Consultation Response from KC, Highways Development Management
2026/90926 3, Lower Rotcher, Rotcher Lane, Slaithwaite, Huddersfield, HD7 5AZ
Erection of two storey and first floor side extensions and formation of parking area with associated works
Date Responded: 8 May 2026
Responding Officer: Sheila Henley
Responding Ref: 1-32/31

Recommendation: No objection subject to conditions and advisories

Plan ref: Proposed Plans and Elevations

Title  
 Proposed layouts and elevations.

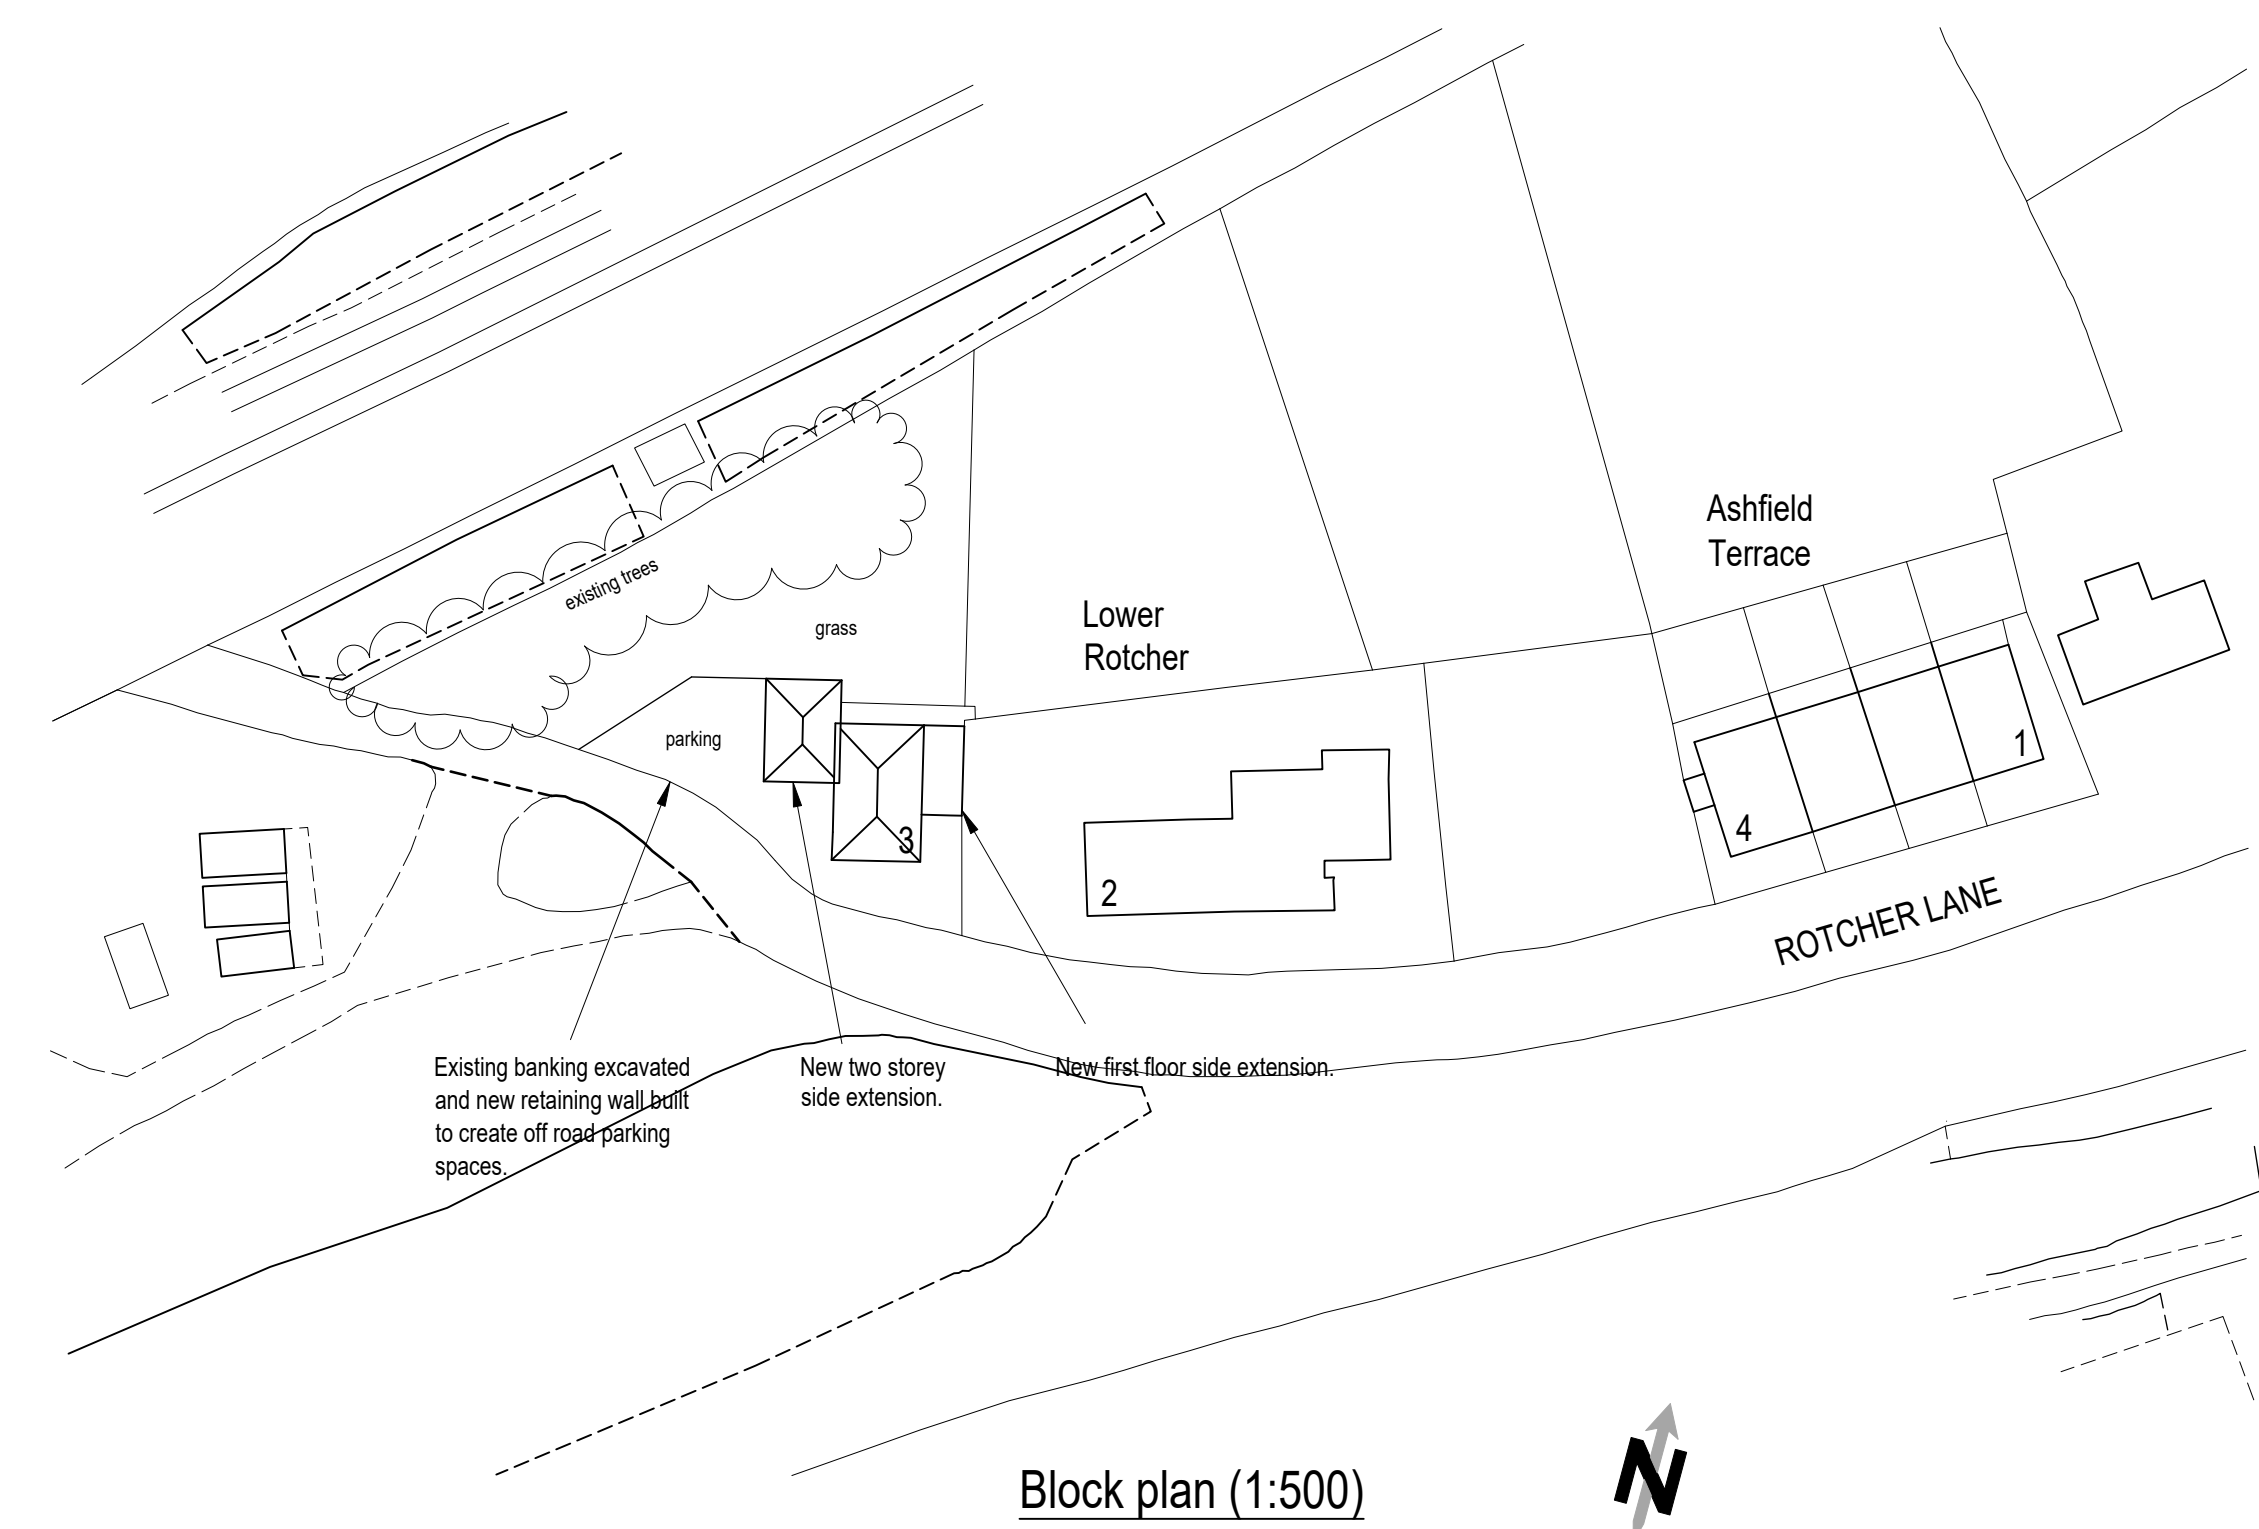
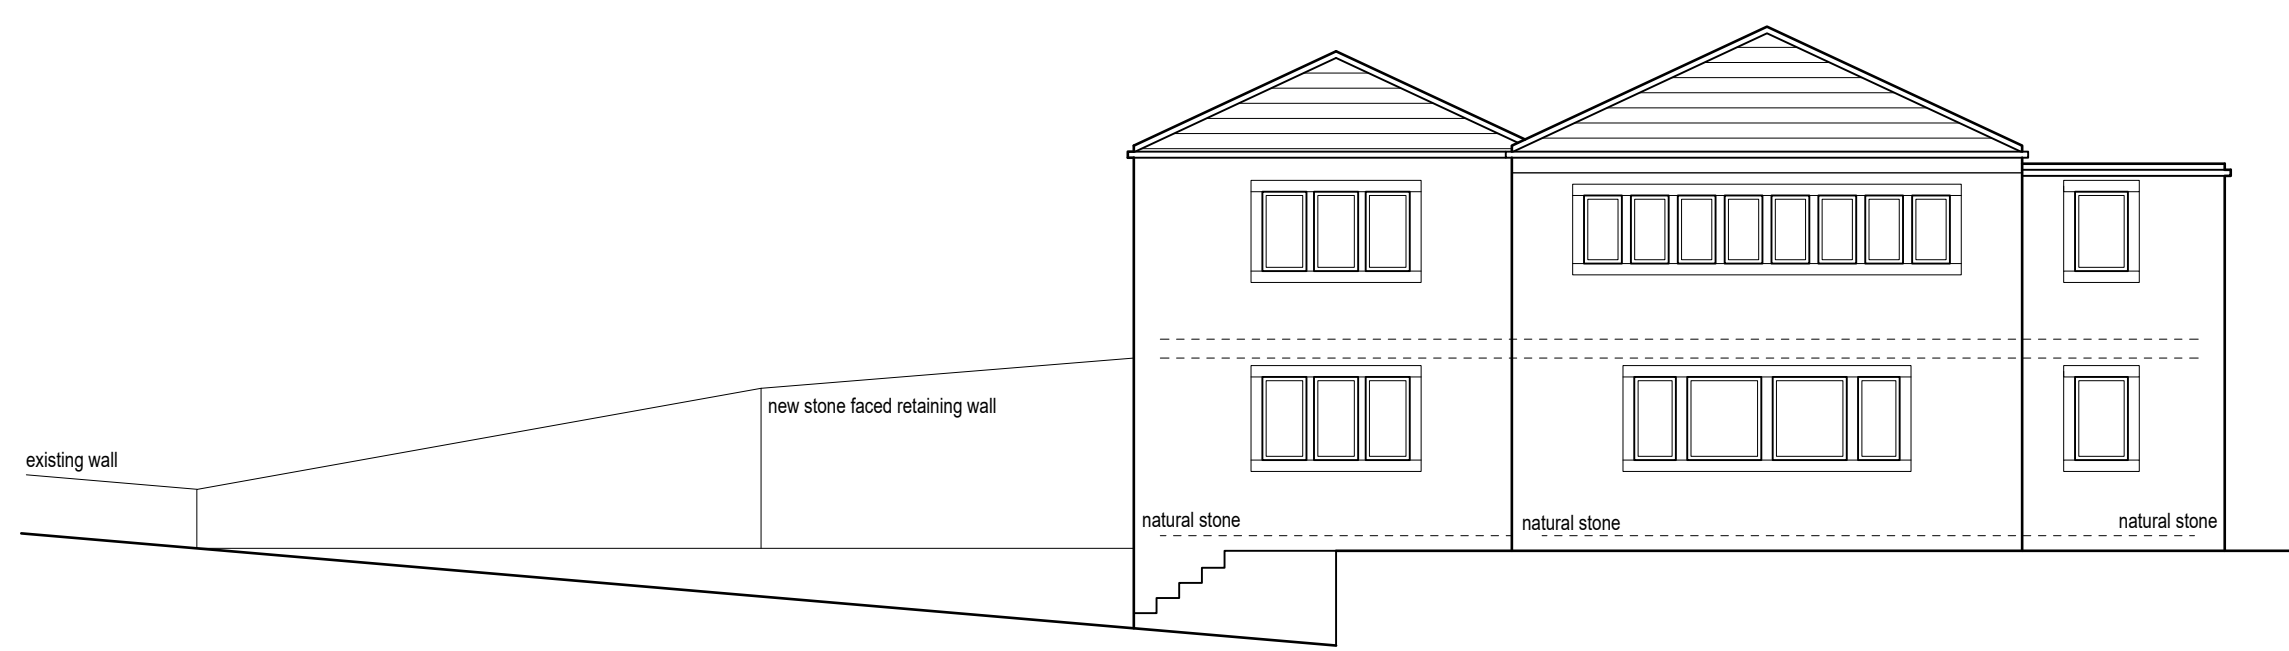
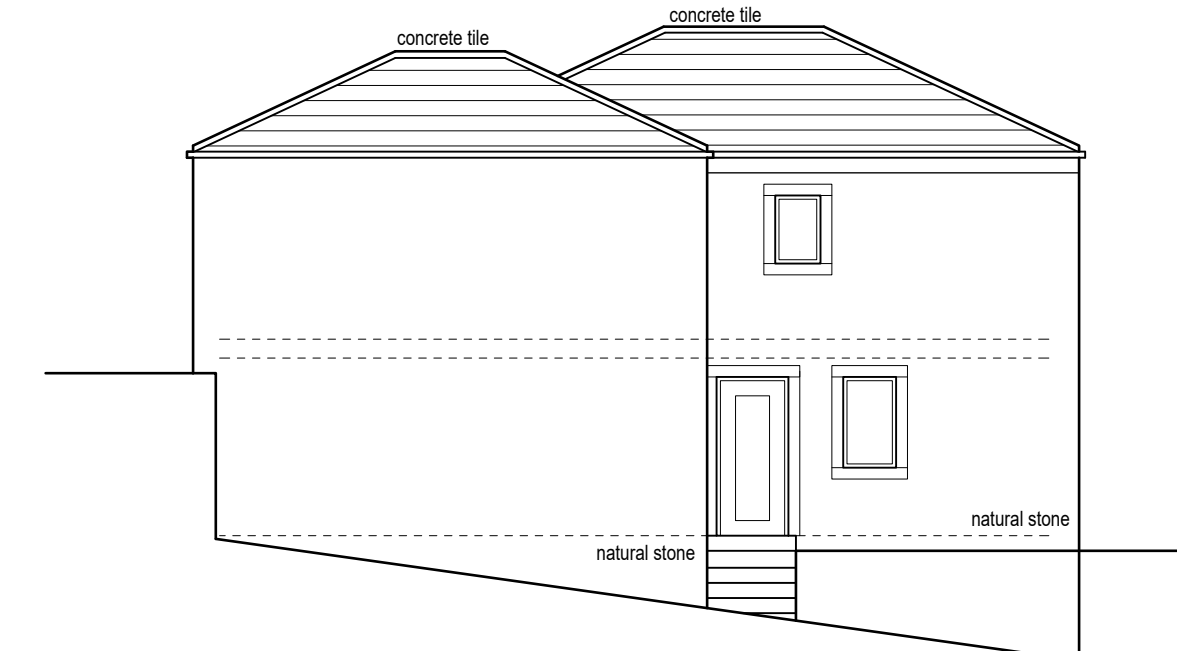
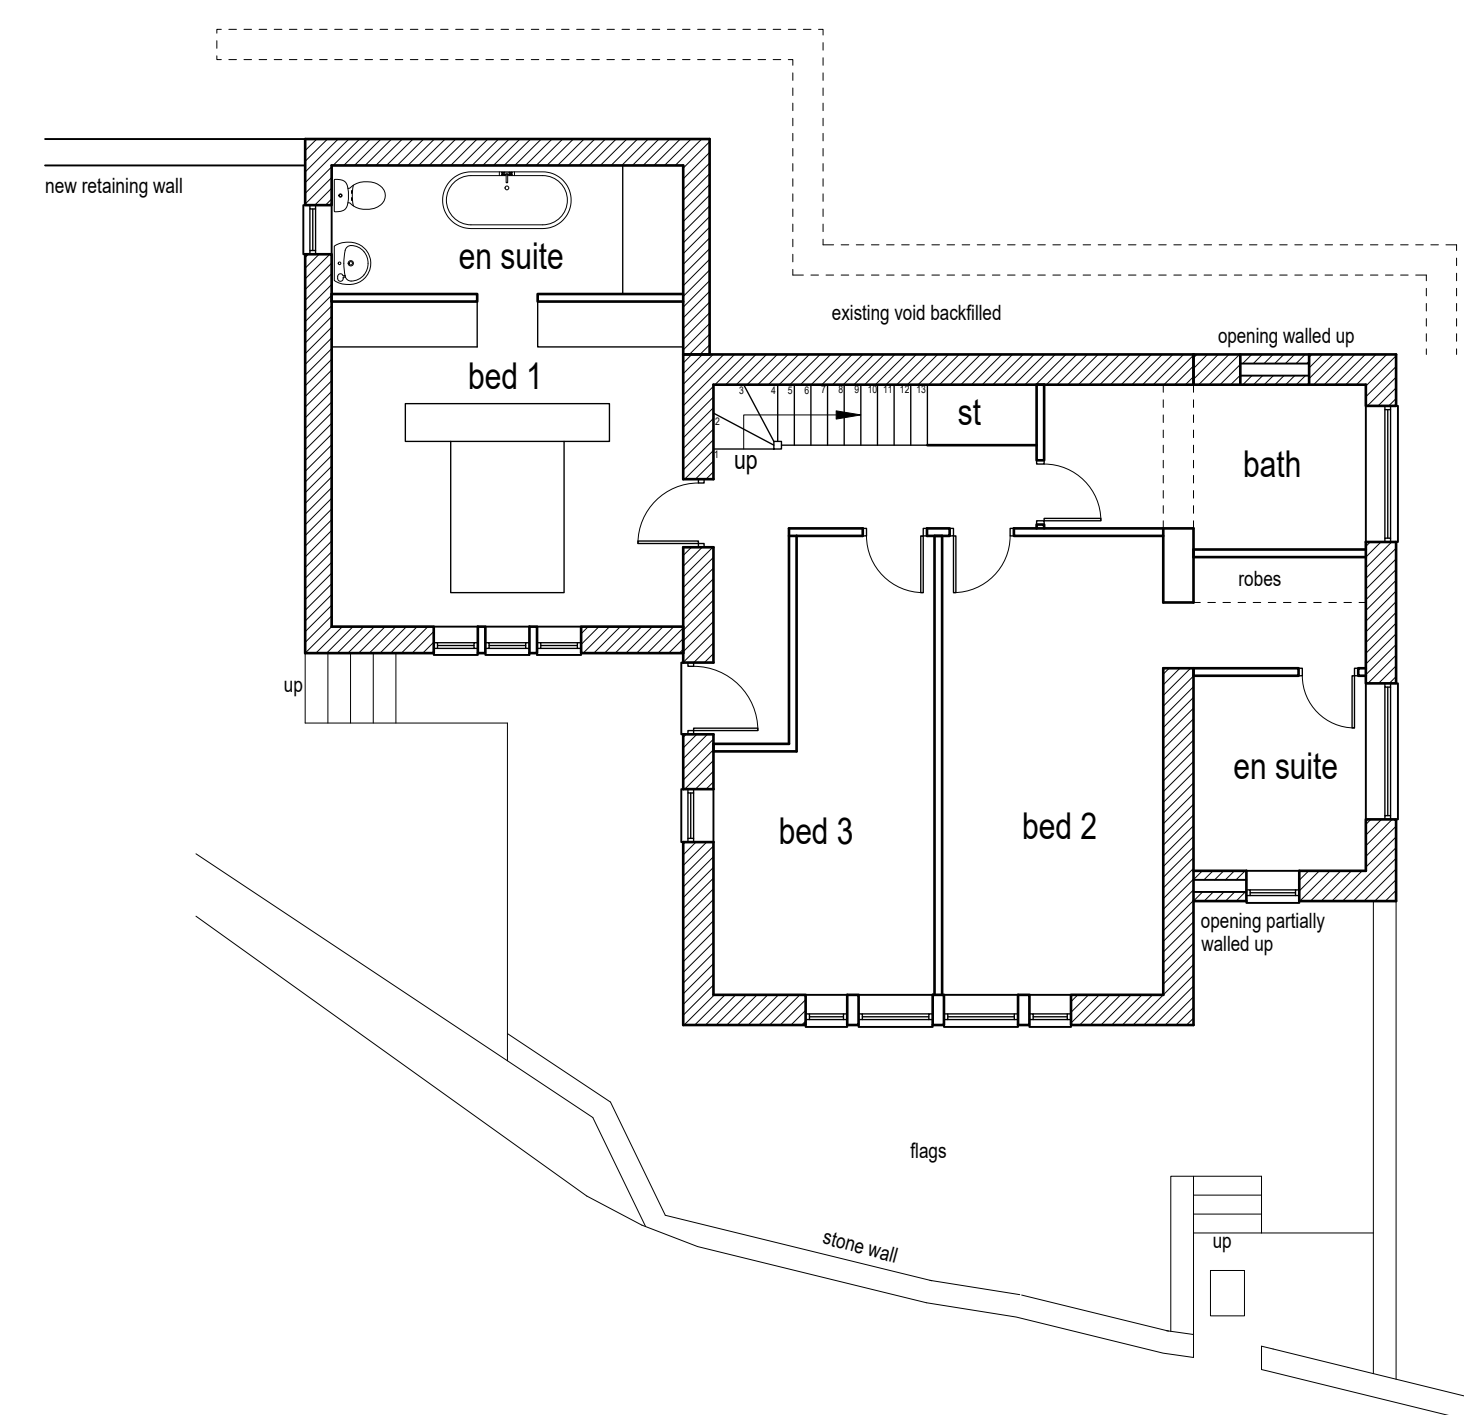
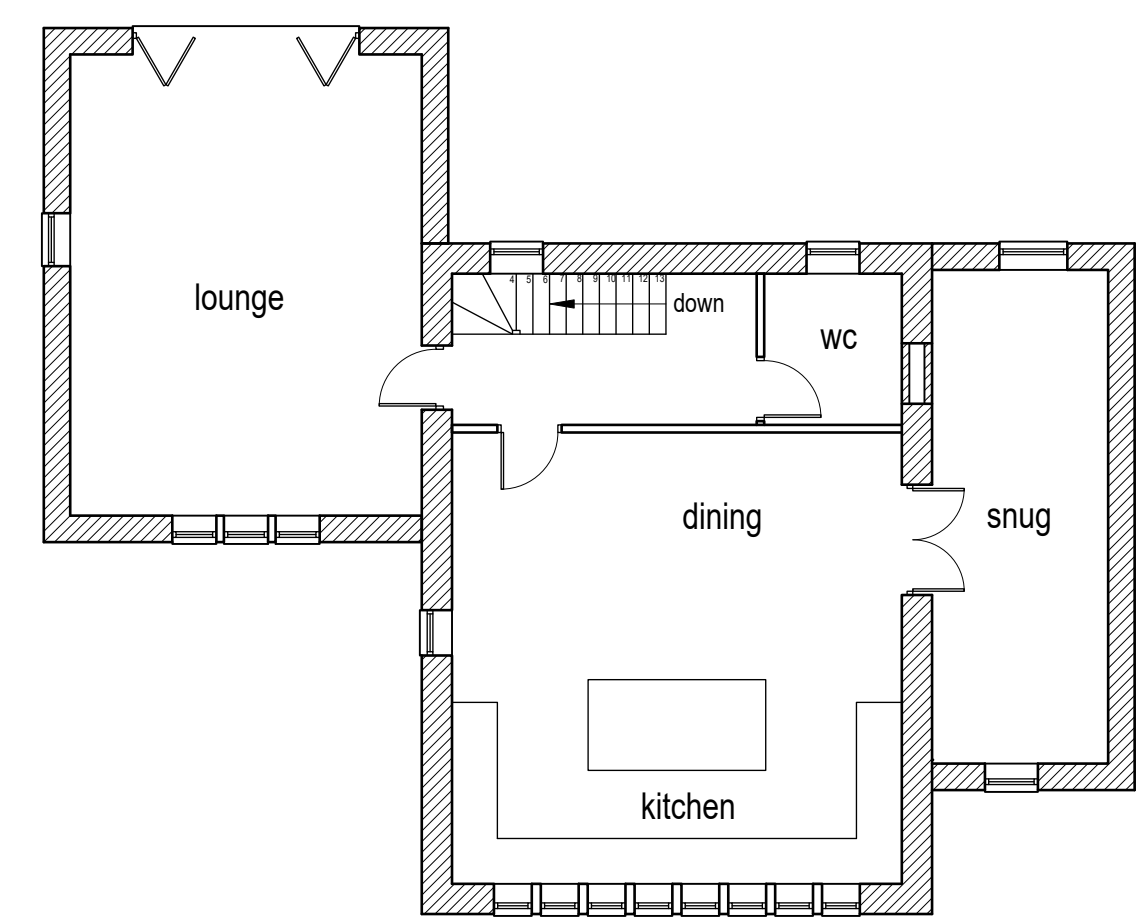
The proposal includes the creation of a new access from Rotcher Lane on removing the existing retaining wall and several trees and providing a new retaining wall after undertaking excavations. The new connection to the public road will require a separate permission from Highways including any relevant structural approval.

Within the site there is to be an area of hardstanding to accommodate off-street parking to serve the existing dwelling on completing the proposed extension.

There would be sufficient space to accommodate at least two cars in line with advice set out in the KHDG SPD for three bedroomed units and to meet policy LP22.

Hardstanding is to be in tarmac which is acceptable on it being permeable or surface water drainage will be needed to prevent run-off onto the highway.

- a) Means of Access: The means of access to and from the site shall be in accordance with the preliminary access design shown on the approved plan named Proposed Plans and Elevations and fully constructed and made operational prior to the development being brought into use and thereafter retained and maintained for the lifetime of the development.

- b) Retaining Walls: Before the development commences a scheme detailing the location and cross-sectional information together with the proposed design and construction details for all new retaining walls/ building retaining walls adjacent to the proposed adoptable/ existing highway together with any proposed modifications to existing highway retaining walls shall be submitted to and approved by the Highway Authority in writing. The approved scheme shall be implemented prior to the commencement of the proposed development and thereafter retained during the life of the development.

- c) Vehicle and Pedestrian Spaces to be Laid Out: No dwelling shall be occupied until all areas and associated features shown on the approved plans to be used by vehicles and pedestrians, including paths and parking areas have been laid out, surfaced and drained, such that loose materials and surface water does not discharge or transfer onto the adjacent highway, and shall thereafter be retained and maintained for the lifetime of the development.
